7 Oct 2021

**SABIC UK PETROCHEMICALS  
TRANS-PENNINE ETHYLENE PIPELINE**

**Planning Application No 3/2021/0278, Ground mounted installation of  
solar array for energy generation  
Location: Dudland Hollins, Gisburn**

*Figure 2 - Panel Arrangement*

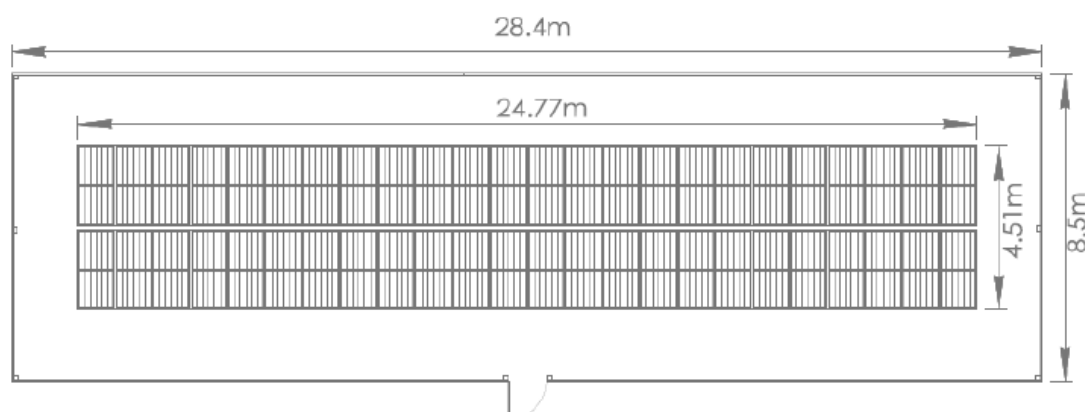
I can confirm that the developer has been in contact with SABIC and a site  
visit has been conducted and the design of the development's fenced area is  
outside the pipeline 6m easement as per SABIC's request.
